Re: Submission SSD-10417-Mod-1 Surface Water - Comments

Regional Hardrock (Dubbo) Pty Ltd, wish to make a submission on the abovementioned application to modify SSD-10417 located on Lots 221 and 222 DP 1247780 Sheraton Road, Dubbo, NSW, 2830 based on the following grounds.

Figure 2: Water management system with surface water diversion

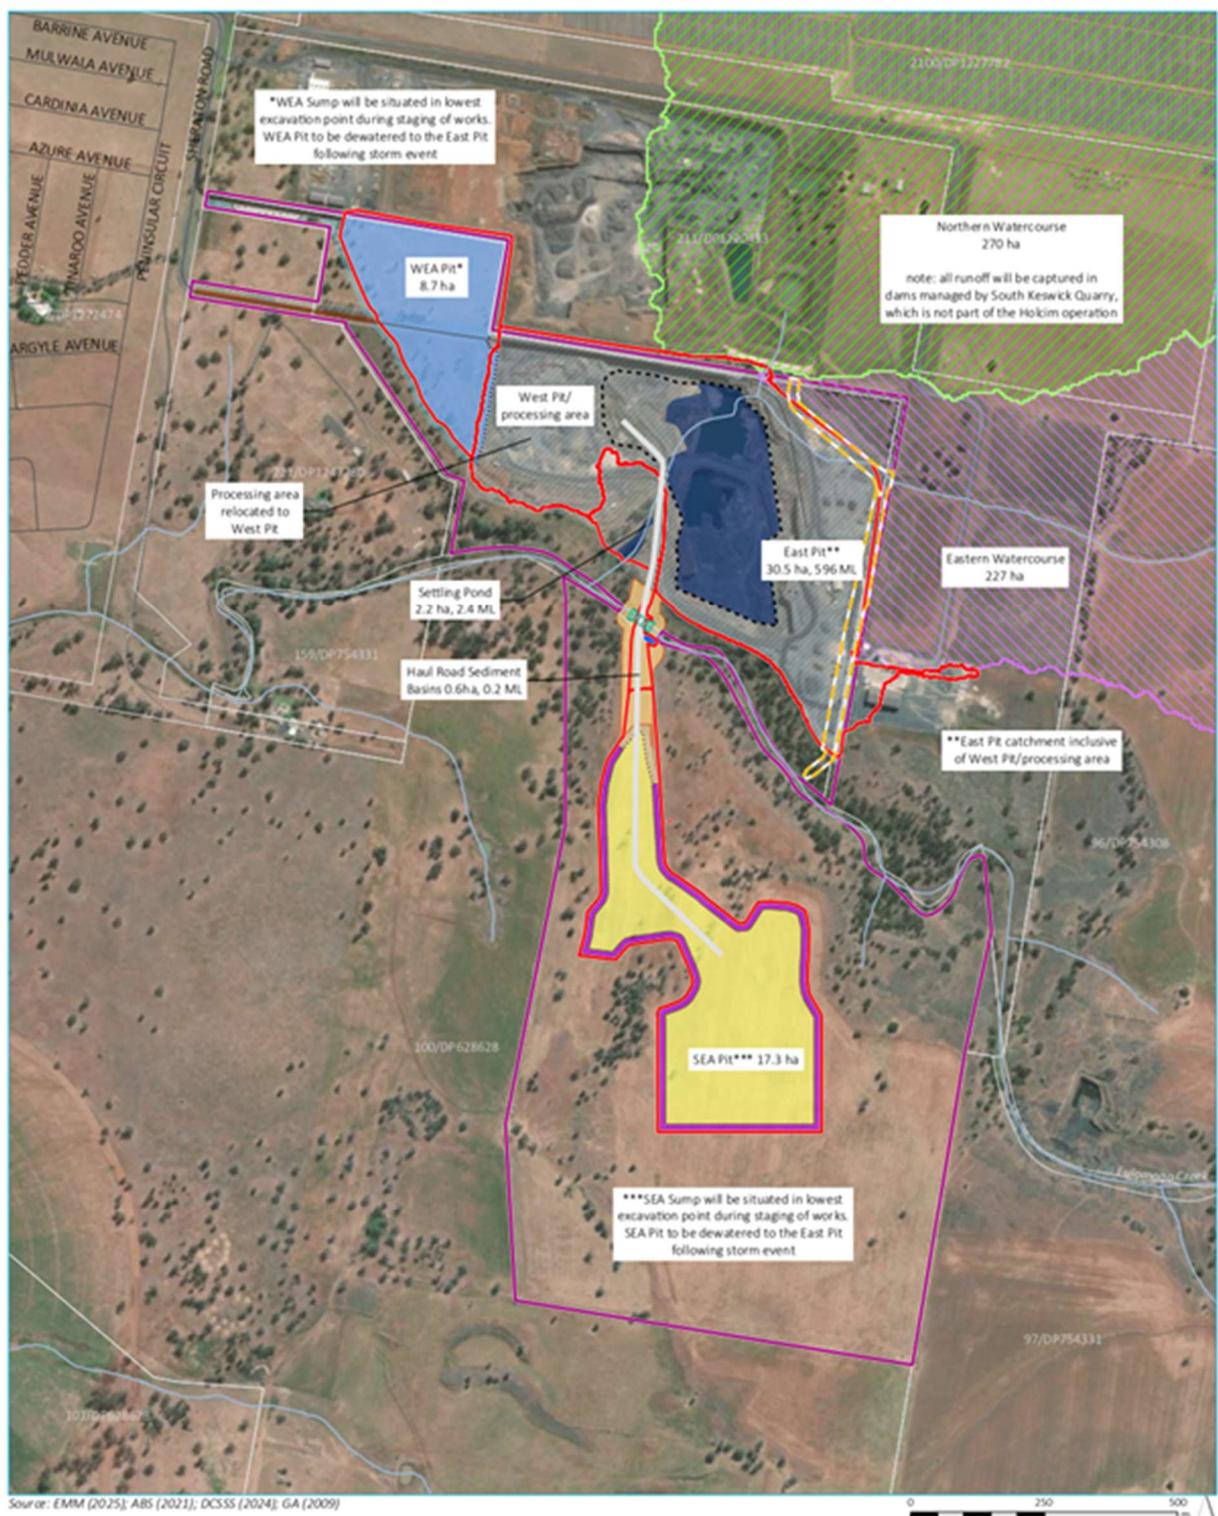
While we support the diversion of surface water away from the operational areas of the Dubbo Quarry, we do so based on making the following comments in relation to the overall site water management strategy as detailed below. Regarding s287 of the EP&A regulation we understand this submission is duly made and is classified as a comment on the proposed development.

Our concern put simply is that the approach to water management in the East Pit has the potential to raise groundwater levels in areas of the South Keswick Quarry approved to extract to levels of 275m AHD. We understand that the Water Management Plan predicts impacts to occur based on the following;

- Historical excavation of the East pit into the underlying pressurised aquifer (paleochannel)
- Cessation of dewatering in East Pit enabling pressurised ground water to rise
- Additional transfer of other quarry water into East pit to form a lake further rising levels
- No monitoring bores located in the paleochannel area were used to establish baseline groundwater levels or monitor future ground water level impacts.

Given this we ask that the Department of Planning to further consider this predicted impact with the applicant through ongoing monitoring of groundwater levels of the paleochannel to validate predicted impacts of rising groundwater levels. Given these concerns we reserve the right to revisit conditions A19, B29-B32 and B39 with respect to this issue upon receiving future groundwater monitoring results from the implementation of this strategy.
